Planning Application Ref: P/152/21/T

Location: 17 Boleyn Drive, Pagham, PO21 3LG

Description of works: 2no. Lombardy poplar trees - reduce by 3-4m to previous cutting points to leave height 8m and spread 1.5m and crown thin by 20%

PLAN TO SHOW POSITION OF
2 LOMBARDY POPLAR TREES IN
REAR GARDEN OF 17 BOLEYN DRIVE
PAGHAM, WEST SUSSEX.

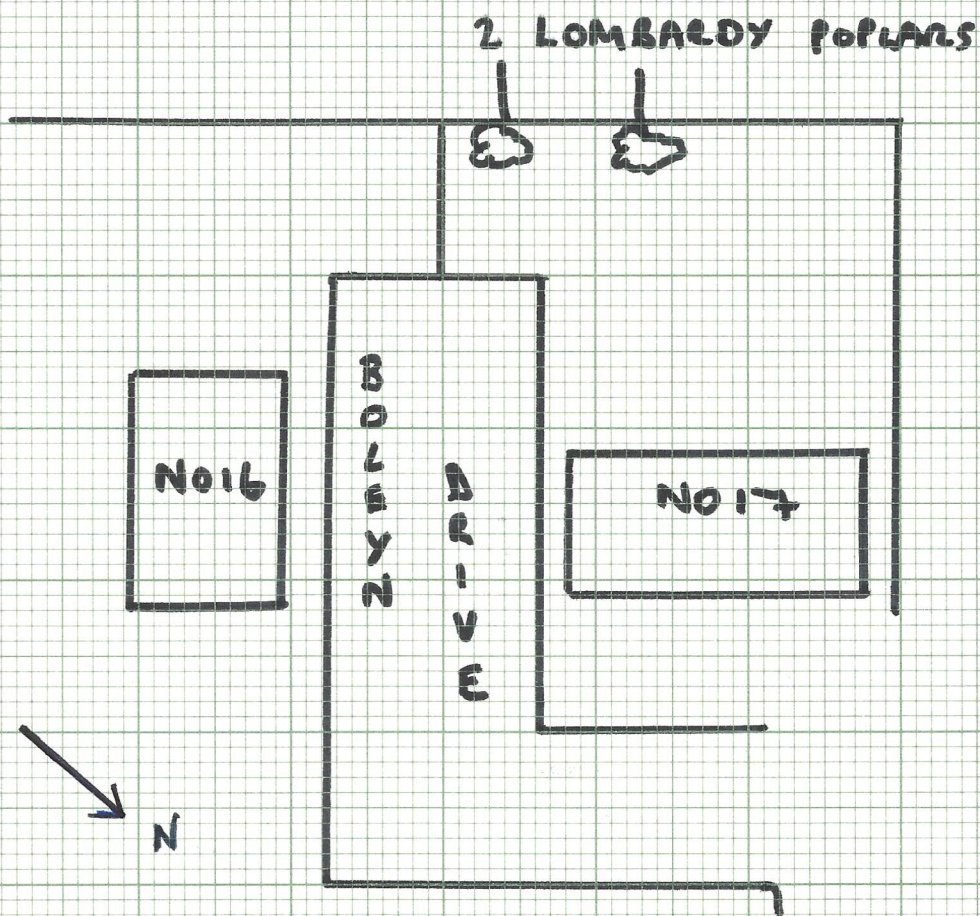
2x Lombardy poplar / *Populus nigra Italica* Height: 10-15m Radial spread: 0-5m Age class: Mature

- I have considered this application by means of a desktop review, using the information and plans submitted as well as online resources. Previous consideration from site and familiarity with surrounding area provides further insight to the proposal.
- They grow at the rear of the property, part of a linear group of the same type spanning several properties. They are visible from surrounding properties and seen in part from public highway. As such, they have some public amenity value despite being aesthetically diminished by severe truncation of their main stems at approx. 8m height.
- Repeat operations such as now being asked for by the applicant will be necessary throughout the remaining lifespan of these trees, to achieve a reasonable degree of structural integrity appropriate for their location.

- The proposal to reduce their overall height and spread with a view to restricting growth is justified and consistent with previous works approved by the Local Planning Authority.
- While a temporary loss of aesthetic value is inevitable, satisfactory canopy renewal and recovery should occur if the work is undertaken to a high standard and at an appropriate time of year.

- I recommend **CONSENT** for this application, subject to the following condition:

Part a) Where whole branches are to be removed and final cuts made close to the trunk or branch union they are to be made as shown in Figure 2 of BS3998:2010

Part b) Where branches are to be shortened back the final cuts are to be made at the correct angle shown in BS3998:2010 and adjacent to a live bud or lateral.

Part c) The removal of crown material which has developed since the last operation must be done sympathetically and with respect to established 'knuckles' so as not to extend beyond the point of origin.
